Comments on NG response at DL4 to Action Pt 34 (8.5.8 – SIH2 Action Points (A) COLNE VALLEY

**10 June 2026 Deadline 5. Penny Lang, [REDACTED]**

A LETTER to the INSPECTORS – A LITANY of FAILURES by the Applicant – N2T

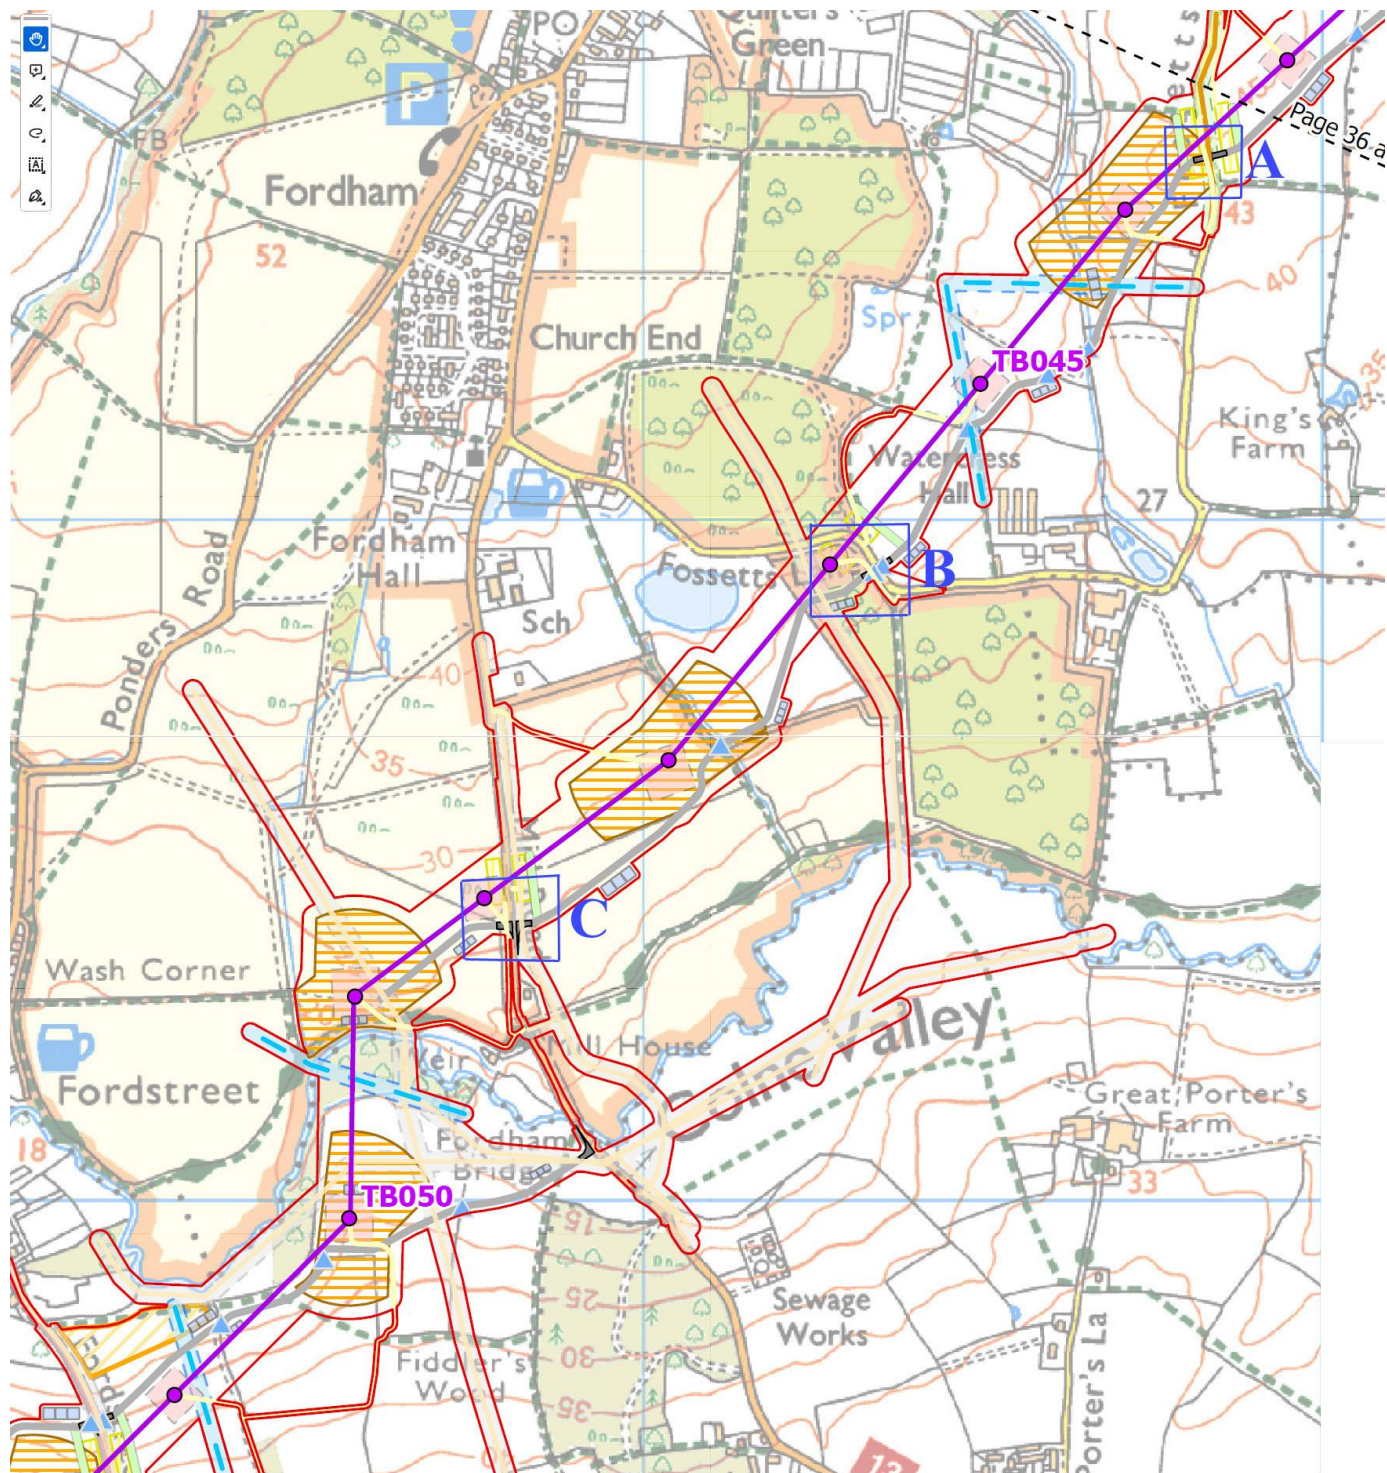
- NG: "and across Mill Road at a point where the Project is able to avoid the Roman Villa excavation site and potential impacts on buried archaeology"

My reply: I understand that the position of pylon TB047 is still not clear: NG statements and maps are at odds, the pylon appears still to sit on top of this sensitive archaeological site.
